Appendix 1A: Cork County Council (CCC) Consultation

Table A.1 Cork County Council (CCC) Consultations

Figure 2.11: XC212 Ballycoskery Proposed Alignment

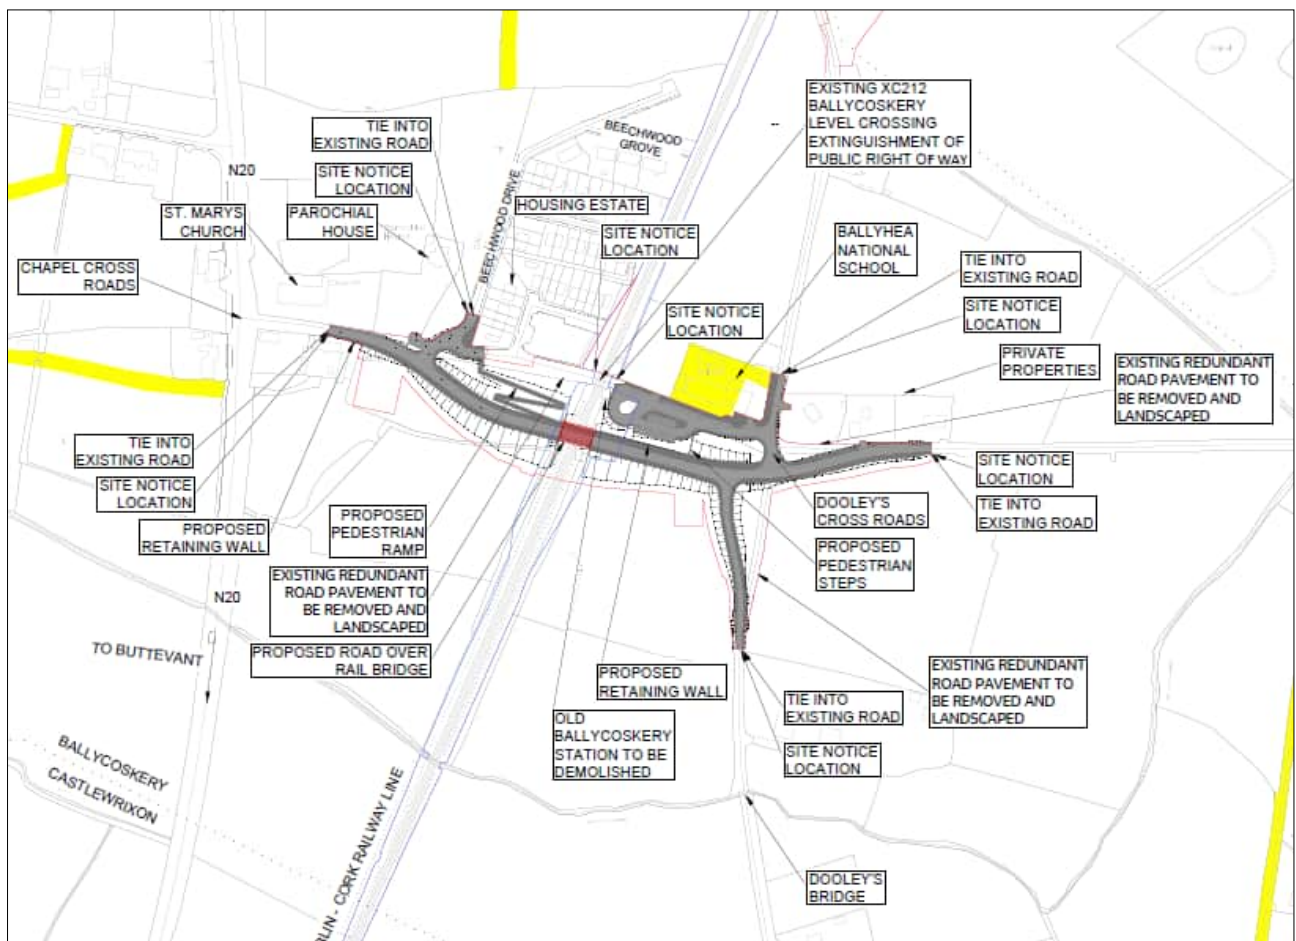
<p>XC212 Ballycoskery:</p> <ol style="list-style-type: none"> 1) Queried use of offline footway – would pedestrians cut across switch-back; 2) Secondary online footpath should be looked at along 8% section of road to avoid people walking on verge; 3) Street lighting would be required along offline footway. Final design by qualified street lighting designer; 4) Queried use of 'Other' carriageway type rather than Type 3. Noted that verge widths are less important, but carriageway width may be required; and 5) Noted that if 60kph design speed not feasible, review of 50kph design speed with mitigations maybe acceptable. 	<p>Jacobs Comments 08/07/2020</p> <p>Offline footway created to allow 5% gradient for pedestrians. Slope of ground across switch back section would likely be too steep to encourage people to cut through.</p> <p>Extension of online footpath now added along the western approach to the structure, however the offline ramped alternative of max 5% gradient is still available to pedestrians if desired.</p> <p>Street lighting will be denoted on offline section of footpath, qualified street lighting designers will specify final design at detailed design stage.</p> <p>Type 3 Single carriageway has been adopted with 3m lane widths, 0.5m hard strips and 3m verge (including hard strip). Road cross section tapers back to existing widths at tie in points.</p> <p>Increase in design speed to 60kph is not feasible with the site constraints. The change in carriageway type to a Type</p>

Comments/queries; Is there any Safety barrier between road and online footpath (or behind the footpath at top of slope) on western approach? – there seems to be a barrier/raised retaining wall on the eastern departure.

Does the offline footway/ramp incorporate intermediate landings (i.e. regular short horizontal 'rest' sections)? Presumably it also will incorporate handrailing and lighting?? M.C.'s comments; the Irish Wheelchair Association's access guidelines recommends that intermediate landings be provided after each 10m slope (@ 1:20). Perhaps the original layout with the greater number of zig-zags achieved this better than the current revised layout?

There is no detail referring to a crash barrier along the southern verge where it is on high embankment leading up to the barrier bridge parapet railing. Surely this is necessary. A few Cross-sections would be desirable to illustrate how all of the elements coalesce. I would suggest on both approaches to the bridge and across the bridge itself, inclusive of the school side retaining wall/parking area on the eastern approach and the pedestrian ramp area on the western approach.

Will this barrier extend through the bridge section onto the eastern side?

Having looked at it closely on site, I generally wonder has the design been optimised on the eastern side in relation to the sag curve between Ch 30 – 90. The attached photos outline the fact that there is a sharp incline towards the Priest's house entrance and an incline into the housing estate entrance, which if capitalised upon may allow the proposed road levels to increase with chainage, (albeit in a sag curve) rather than the current vertical alignment, which has the proposed road levels dropping to a low point in advance of the 7% gradient. I would appreciate if this was given some consideration but will accept if it is simply not a feasible option.

3 Single also means that the western approach gradient was required to be reduced from 8% to 7% to avoid an additional departure, adding additional constraints.

As per TII Rural Road Link Design, the Design Speed should be consistent with the anticipated vehicle speeds on the road and is not directly related to the mandatory speed limits. Traffic survey results at this location show an 85th percentile vehicle speed of 53.3kph.

Carriageway and online footway are also separated by both a verge and safety barrier, improving pedestrian safety and limiting interactions between vehicles and pedestrians along the main stretch of the carriageway.

Cork County Council Consultee (CCC) Responses	
	<p>There is currently a barrier at the top of the retaining wall to the east of the bridge structure but neither section of online footpath adjacent to the grassed embankment have barriers proposed.</p> <p>The online footway to the east of the bridge structure was designed to the recommended longitudinal gradient of max 5% (DN-PAV-03026 Footway Design Table 2.3). To the west of the bridge structure, the footway was taken offline to enable the continuation of this 5% gradient. It was not designed as a pedestrian/wheelchair ramp with landings. Although in saying that, the changes in direction would necessitate a type of landing area. Similar to the sections of online footway adjacent to grassed embankments, there would be no handrail proposed along this offline footpath.</p> <p>Similar to comment below in relation to the extent of safety barrier, the attached General Arrangement drawing shows the extent of the safety barriers along all section of high embankment. Barriers are shown as purple or orange lines, as noted in the GA drawing legend. We are currently in the process of producing contiguous elevations through the road works in relation to adjacent properties, I have added an excerpt from one such in progress drawing as Figure A below, showing the safety barrier locations on the road cross section.</p> <p>As shown on the General Arrangement drawing (attached for reference), the purple line denotes the H4a barrier running along the carriageway edge, through the bridge structure, and on approach to the structure on either side. The orange line then denotes the N2 barrier that then continues to the east and west of the structure from approx. Ch80 to Ch320</p> <p>I have attached a profile drawing of the mainline, including the alignment profiles of the side road at Ch70 ('Northwest connector') and the link to the priest's house ('Northwest connector – Left Access') showing the mainline SAG curve and the tie in to the Priests house have been maximised where possible.</p>

Figure 2.13: XC215 Shinanagh Proposed Alignment

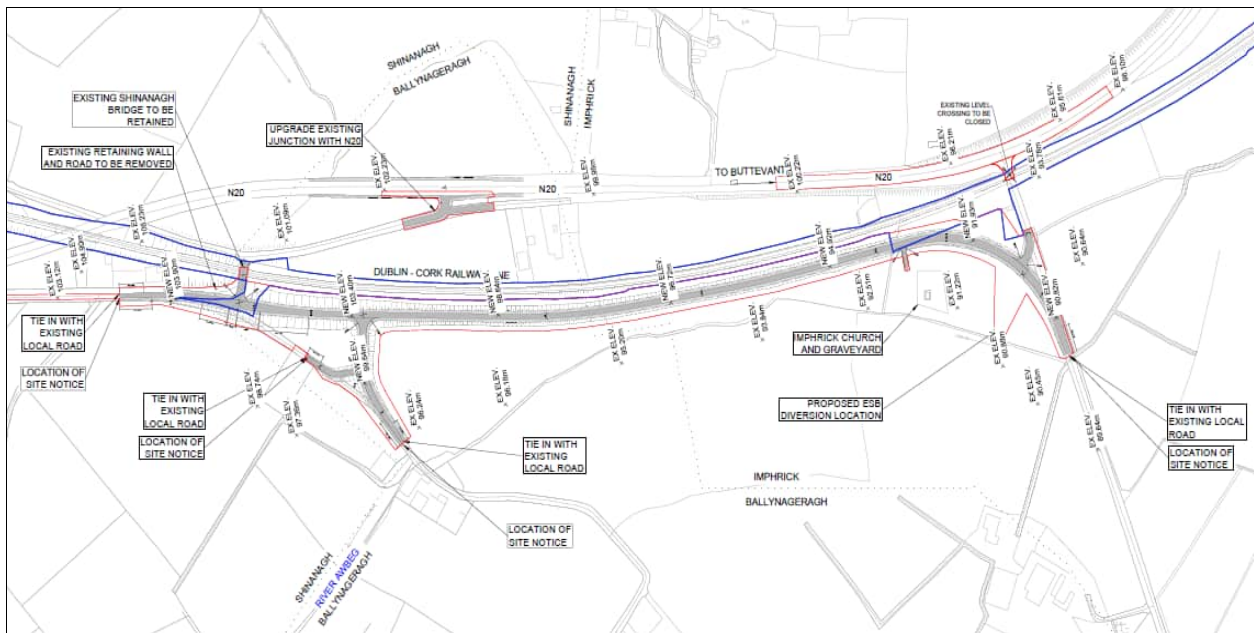
<p>XC215 Shinanagh:</p> <p>1) Queried use of 'Other' carriageway type rather than Type 3. Noted that verge widths are less important, but carriageway width may be required;</p> <p>2) 5.5m carriageway width may be acceptable at tie-in to existing, but Jacobs to review widening of carriageway at bend, with hatched road marking used; and</p> <p>3) Queried if there was enough width on existing N20 to add new right turn lane. Noted that probably enough room in the hard shoulder as this was the case when adding the existing right turn lane at the level crossing. Noted that length of RTL should be checked.</p>	<p>Jacobs Comments 21/05/2020</p> <p>Carriageway upgraded to Type 3, however, as per meeting note 16 below, we have applied a departure in the cross section of 5.5m carriageway width to tie in with existing road widths. Carriageway has been widened at bend and road marking added.</p> <p>Topographic survey required to confirm existing N20 pavement width. Right turn lane dimensions have been checked and will be fully designed at detailed design stage.</p> <p>Cork Co. Co. Response</p> <p>5.5m would be acceptable as a compromise provided that Item 4. Below is conceded.</p>

<p>XC215 Shinanagh:</p> <p>1) Retain the proposed tie-in from N20 to existing bridge to T-junction with new road;</p> <p>2) Traffic approaching on N20 from north to be directed to turn right at N20 junction north of existing bridge. This would remove need for new right turn lane;</p> <p>3) Traffic from Churchtown wanting to go south on N20 to be directed right over existing bridge and right at N20 junction. Or</p>	<p>Jacobs Comments 21/05/2020</p> <p>Would this solution still be agreeable to Cork Co. Co. if we did not include the 350m of road resurfacing in the scheme (as per response to comment 4 below).</p> <p>Issue 3 Agreed.</p> <p>Alignment ties in 135m from existing bridge and 350m from existing N20 junction to north. The upgrade of existing road is outside the scope of this project. We also have no survey information on the conditions of the existing road so it would not be possible to quantify the</p>

Cork County Council Consultee (CCC) Responses	
<p>they could travel past existing bridge to N20 junction north of existing bridge; and</p> <p>4) Alignment appears to end half way between existing bridge junction and existing N20 junction north of existing bridge. Existing road at this point is 4.5m but has adequate width and hardstanding to increase this to uniform width of rest of proposed alignment. Recommend resurfacing and uniform width extended northwards as far as junction with N20, given that this would be used by Churchtown bound motorists approaching from N20 north.</p> <p>5) Retain the proposed tie-in from N20 to existing bridge to T-junction with new road</p>	<p>extent of works required to upgrade this existing section of road.</p> <p>Agreed issue 5.</p> <p>Cork Co. Co. Response</p> <p>Noted. The project obviously needs to make provision for the installation or moving of Advanced direction signs on the N20 or elsewhere and will need to consult with TII on the changes proposed to the national route signage.</p> <p>It would be acceptable and preferable provided that if it allowed for the resurfacing of the 350m length to the 5.5m pavement width proposed along the remainder of the diverted route. The existing right turn lane north of Shinanagh Bridge is deemed a safer option than the one proposed south of the bridge and there are also concerns about the safety of diverting all the traffic across the old skew bridge with its blind 90-degree bends. Irish Rail need to consult with TII in any case for either option as there will be a changed number of right turn movements in either case.</p> <p>Cork County Council considered that it would not be safe bringing traffic along an improved road and merging back into an unimproved road with a narrower surface area (currently 4.5m) in advance of that road's intersection with the N20 road, a mere 350m further along. No matter what the configuration it is highly unlikely that traffic heading north on the new road (from Churchtown side) will divert right at the skew bridge, going back on themselves, so it is imperative that this form part of the scheme. This element of the road was originally the N20 and hence the potential is there to widen it as it would surely have been at least 7m wide previously.</p> <p>Noted issue 5.</p>

Cork County Council Consultee (CCC) Responses	
	<p>Agreed. Note that Area Engineer has pointed out the Irish rail need to ensure that the revised access to Imphrick Old Graveyard is agreed with the landowner as it transfers the field crossing point to a new location.</p> <p>Noted in relation to issue 3.</p>
<p>XC219 Buttevant:</p> <p>1) Queried use of 'Other' carriageway type rather than Type 3. Noted that verge widths are less important, but carriageway width may be required; and</p> <p>2) Noted departures on horizontal alignment could be agreeable is sufficient visibility was given. Vertical departures could be mitigated with warning signs and possible addition of street lighting to bridge. Noted street lighting at top of bridge would not impact adjacent dwellings.</p>	<p>Jacobs Comments 21/05/2020</p> <p>Carriageway upgraded to Type 3, with 6m carriageway, 0.5m hard strip, and relaxations on the remaining 2.5m verge in locations.</p> <p>Horizontal Geometry:</p> <p>Two 180m radius curves (4 steps below DM for 85km/h) are required at the eastern end of the scheme due to site constraints tying into existing road and minimizing impact on existing properties at the tie in and in the Irish Rail yard at the bridge structure. Tight constraints also limited the road length available for transitions curves at this location. One 360m radius curve (1 step below DM) was required at the western tie in.</p> <p>Vertical Geometry:</p> <p>One K=17 crest curve over the bridge structure (2 steps below DM) was required at the bridge structure due to the constrained length of road available to tie back down to existing levels. Two K=13 Sag curves (2 steps below DM) were required to tie back into existing levels at either end of scheme. Max vertical gradient of 7% on western approach to bridge.</p> <p>SSD:</p> <p>The existing property boundary wall at approx. Ch 0+500, and the 180m Radius curve, reduces the E-W SSD to 90m at this location, 2 steps below DM. The same property boundary wall also reduces the W-E direction SSD to 120m at this location.</p> <p>The northern pedestrian guardrails over the structure parapet and retaining wall reduce the horizontal SSD in a W-E direction to 90m over the length of the guardrail.</p> <p>There is full visibility to the top of the crest curve from both directions, however the reduced crest curve leads to a reduced SSD over the crest curve of 90m (2 steps below DM) for low object visibility.</p> <p>Mitigation:</p> <p>Footpath and lighting have been extended to the top of bridge This will allow pedestrians to cross at a safer location, at the top of the crest curve, with full visibility from both directions. W140 warning sign (Pedestrians) is located either side of the bridge to warn oncoming vehicles.</p> <p>A W009L warning sign (Side Road on Outside of Left Bend) will be located east of the scheme tie in to warn oncoming vehicles of the sharp bend and the minor access road to the right.</p>

Figure 2.15: XC219 Buttevant Proposed Realignment

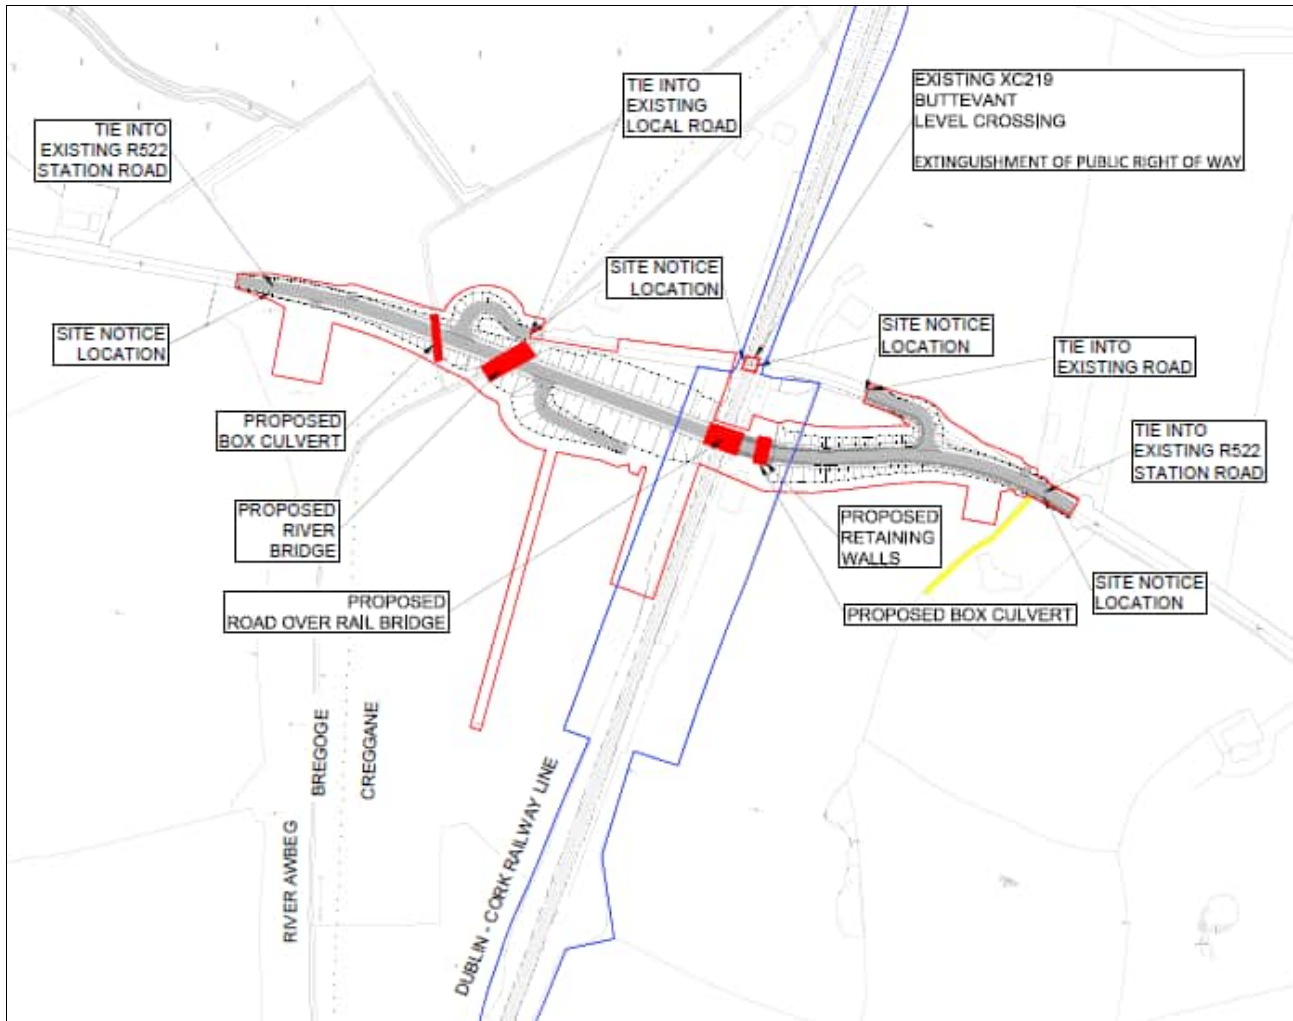
<p>XC219 Buttevant:</p> <p>1) Area Engineer in agreement with Michael Cotter that road should be Type 3 Single with carriageway 6m and verge 3m (inclusive of hard strip);</p> <p>2) Concern regarding safety of pedestrians/cyclists crossing the bridge as crash barriers shown close to road edge giving minimal room for ped/cyclists to step in;</p> <p>3) Recommend extending footpath to bridge on one side and widening verge on far side to allow step in; and</p> <p>4) Recommend lighting to also extend to the bridge.</p>	<p>Jacobs Comments 21/05/2020</p> <p>Carriageway has been upgraded to Type 3 Single. 6m carriageway, 0.5m hard strip, relaxations in the remaining 2.5m width of verge at locations.</p> <p>The crash barrier has been moved back to 1m from the pavement edge. This, along with the 0.5m hard strip allows sufficient room for pedestrians/cyclists to step in off the road if required.</p> <p>Proposed lighting has been extended to the bridge in line with extended footpath.</p> <p>Cork Co. Co. Response</p> <p>Acceptable in relation to all issues.</p>

Cork County Council Consultee (CCC) Responses	
	<p>A W053L warning sign (Series of Sharp Bends – Left) will be located west of the bridge to warn oncoming vehicles of the road geometry beyond the bridge crest curve.</p> <p>Cork Co. Co. Response</p> <p>Cork County Council are satisfied with this response.</p> <p>Cork County Council acknowledge that the design is a best fit to the local constraints, whilst still maintaining a reasonable standard, with mitigating measures such as road markings, signage and crash barriers to overcome necessary relaxations/departures. Difficult to judge elements of the plan and elevation as they will only print off in A4 size. Typical Cross sections would be helpful on either approach to the bridge and on the bridge itself. Some concern about the safety of pedestrians who may cross at the uncontrolled crossing on Buttevant side of the rail line and Council would require a Stage 1/2 Road safety Audit of this particular scheme given the scale of the project and the interaction between different modes. The results of such audit need to be made available to Cork County Council along with any mitigating proposals deemed necessary.</p>
